Our Ref: 20/01336/FUL  
Your Ref: 9a Palmerston Road

LOCATION: 9A Palmerston Road, Southsea, PO5 3QQ

PROPOSAL: Change of use from dwellinghouse (Class C3) to purposes falling within Class C3 (dwellinghouse) and Class C4 (house in multiple occupation)  
**(20/01336/FUL)**

Drawing Title:
 Proposed Floor Plans

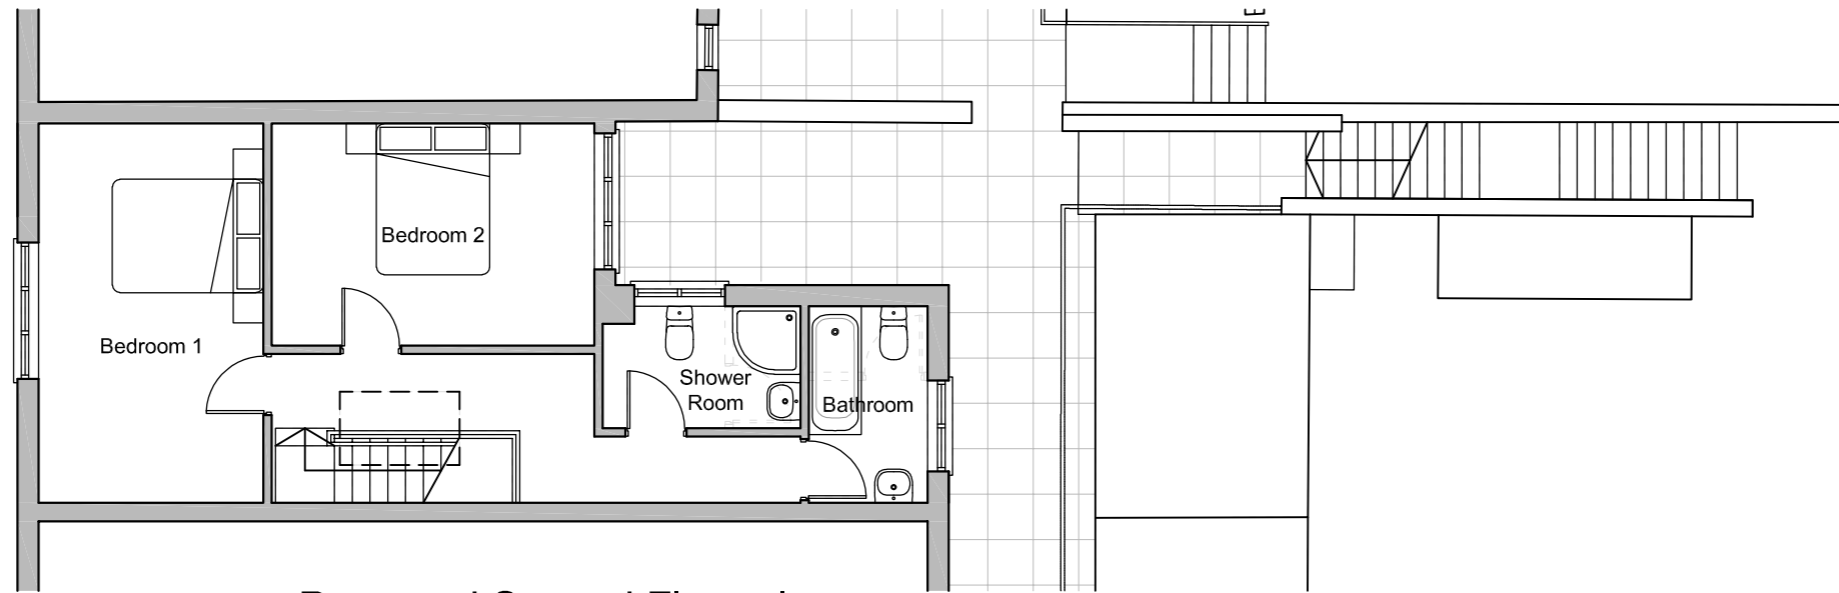
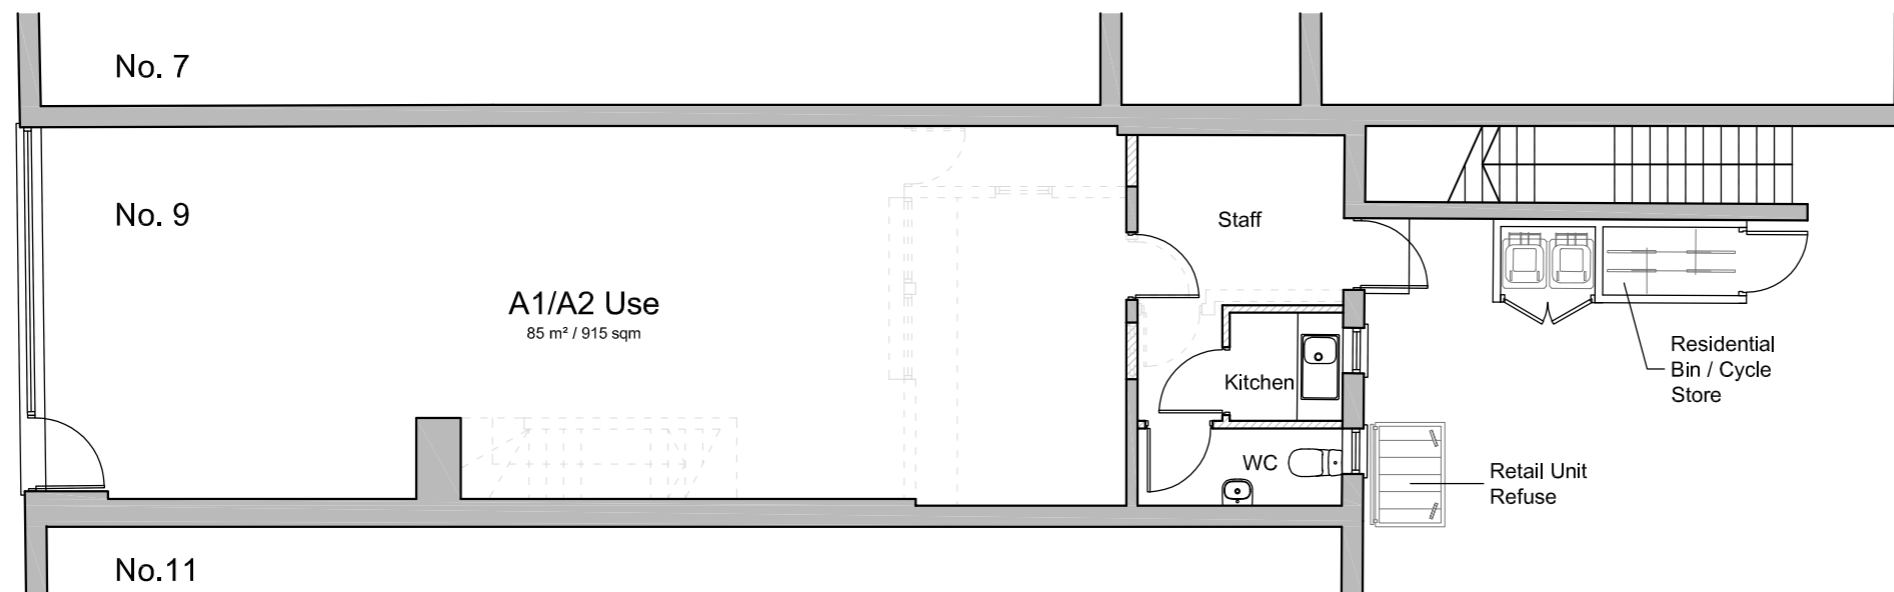
Floor plans submitted are 1:100 but do not scale correctly, 5m measures at 3.45m. Please resubmit the floor plans to correct scaling.

There are one set of floor plans 'proposed' submitted. Please advise why you have not submitted existing floor plans, i.e., state if there are to be no internal alterations.

The planning application relates to a new C4, the floor plans must also contain the following information, as per Para. 1.17 HMO SPD:

- be supported by a full set of floor plans that include details of the bathroom sanitary ware and **kitchen fitments and white goods**
- clearly identify whether rooms are intended to be single or double
- show the internal measurements for each room, including areas of reduced ceiling height

Drawing Title:
 Location Plan
 Block Plan

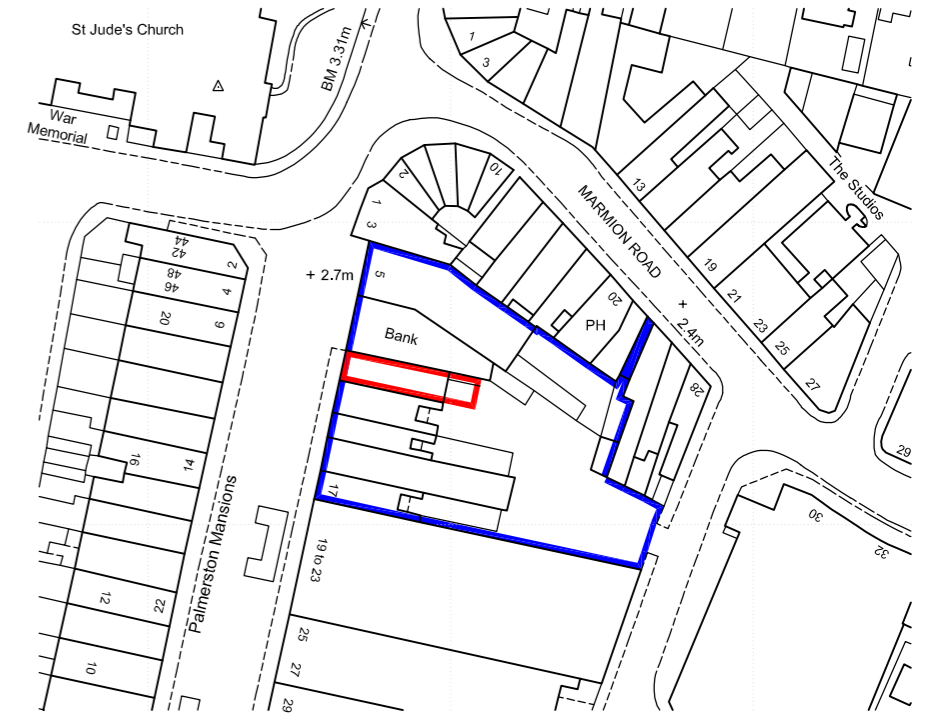
- 1) Please confirm that Certificate of Ownership A is correct, as there are other properties within the red line, including unit 1 and 2 at 9 Palmerston Road. The surrounding area has a blue line, does your client own all the properties within the red and blue line?
